Objection To :- The Uniting Kingscliff Redevelopment (SSD47105958)

I live at 37 Drift Court Kingscliff and am a direct neighbour to the proposed Uniting Kingscliff Redevelopment (SSD47105958). I object to the development in its current form based the items listed below.

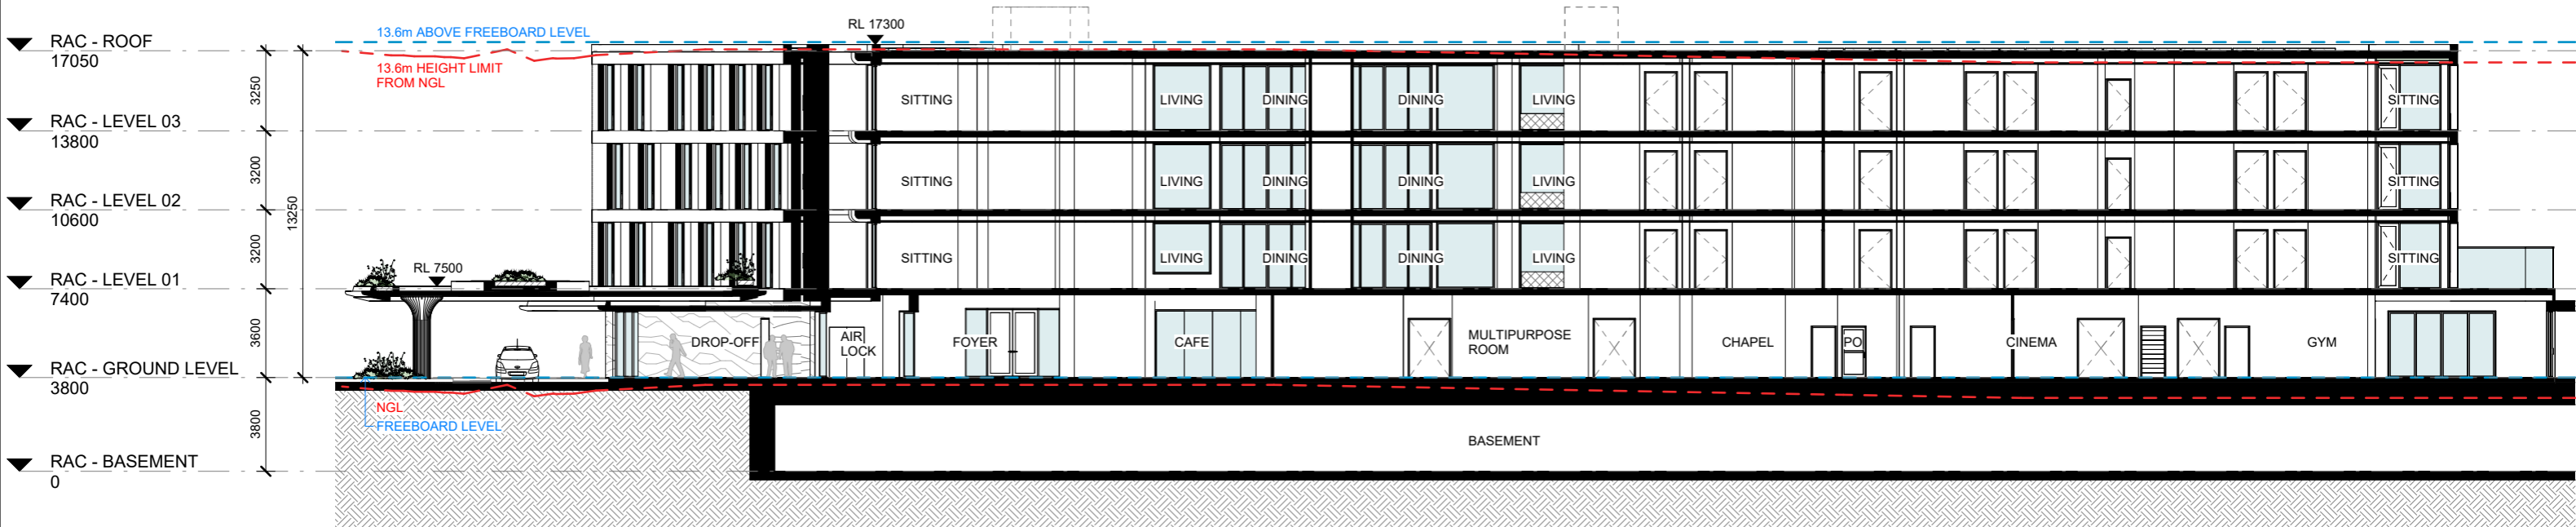
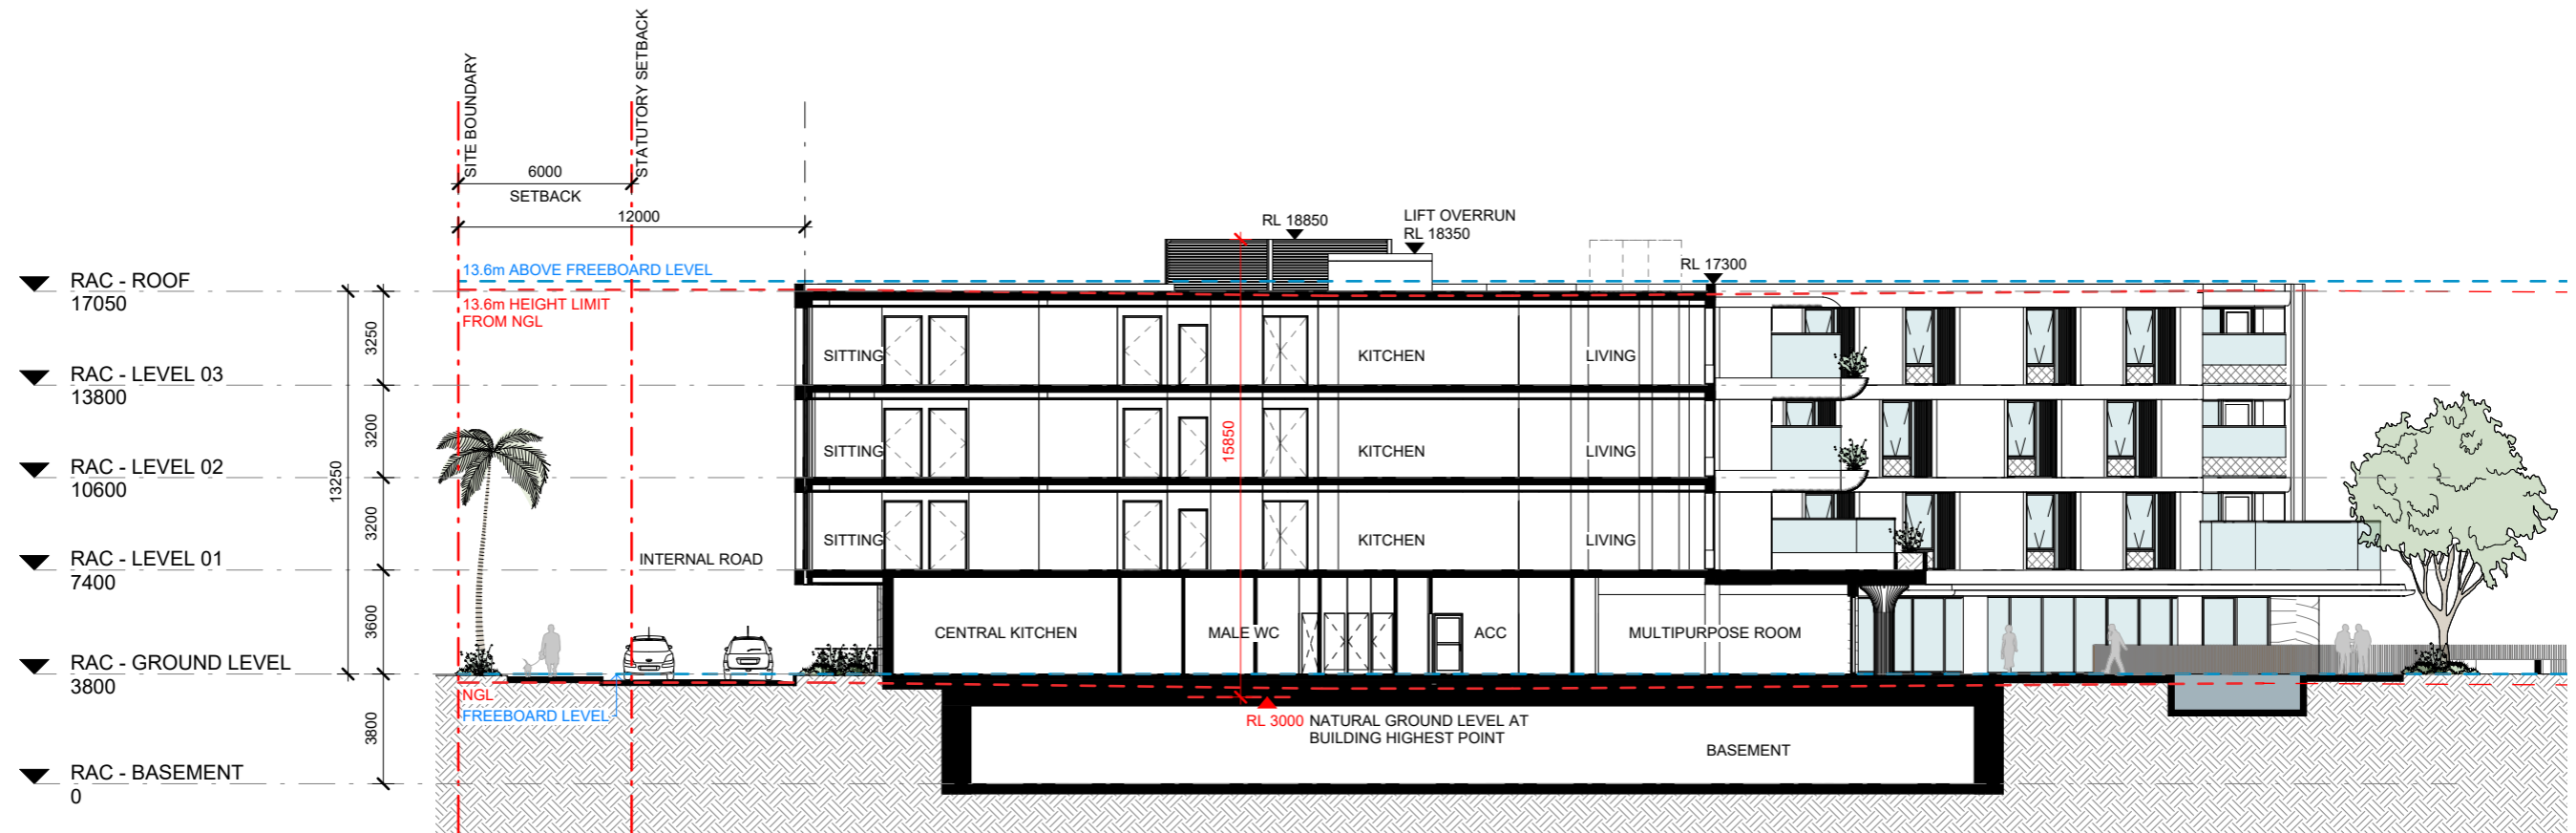
Section 04 - Building C North

Heights Nominated on plans incorrect. Ground level above my floor level.

- How is this in context with the surrounding built environment.
- Minimal set back of upper roof. Was this section omitted and overstated in justification of height increase.
